From: Dominic Smith [REDACTED]
Sent: 03 August 2017 14:57
To: Andrew Wood
Subject: RE: Consultation response - FG/198/16/PL

I note on the response attached you have referred to a 'total capacity of 10 car parking spaces.
There are also 2 car parking spaces on the road frontage outside of the basement on Sea Drive which makes a total capacity of 12 cars. Could you amend your response accordingly and confirm that the development now meets the West Sussex Parking Demand Calculator for the development.

JOB: 1 SEA DRIVE, FERRING, WORTHING BN12 5HD
DWG: PROPOSED SITE PLAN

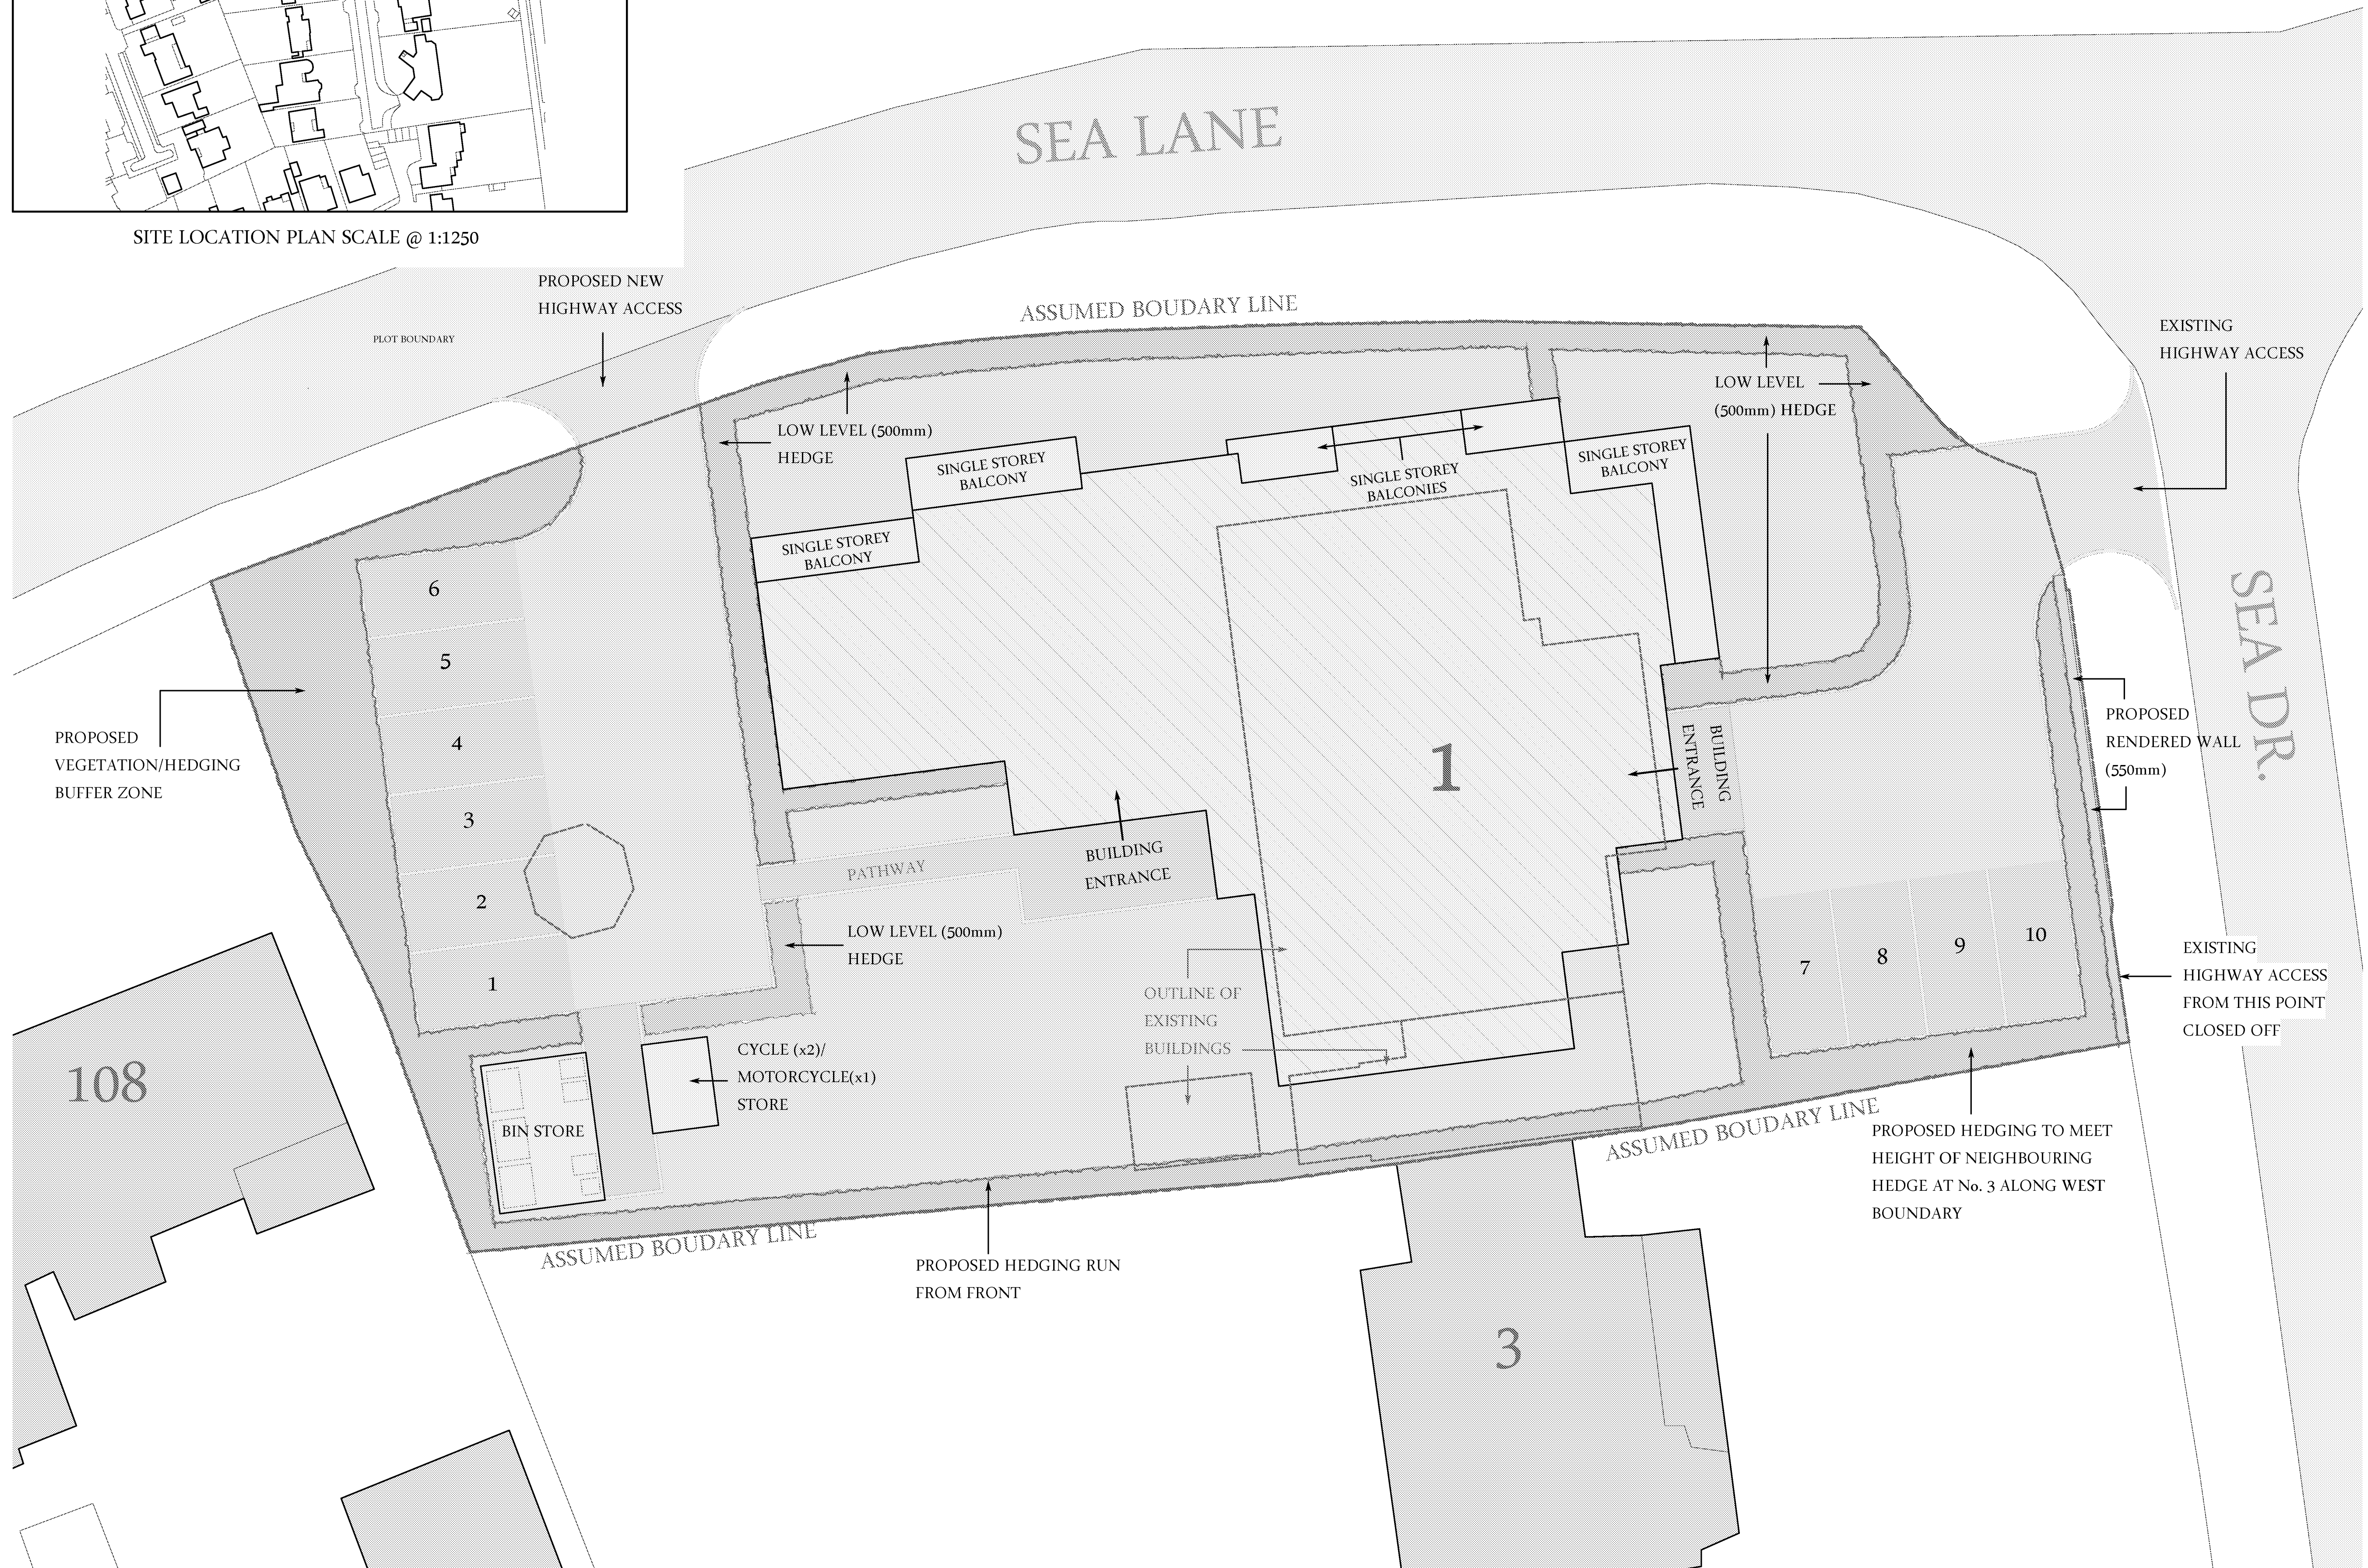
The LHA response referred to the capacity of the car park being 10 spaces. The two surface level spaces are noted.

In respect of the Parking Demand Calculator there are two options. If none of the parking spaces are to be allocated (i.e. all spaces are available for residents/visitors to use without) then the demand would be for seven spaces. If each flat was allocated a single space, with the remainder of the spaces remaining unallocated and available for unrestricted resident/visitor use, then a demand for 11 spaces would be generated. In either scenario, the proposed provision of 12 spaces would exceed the anticipated demand.
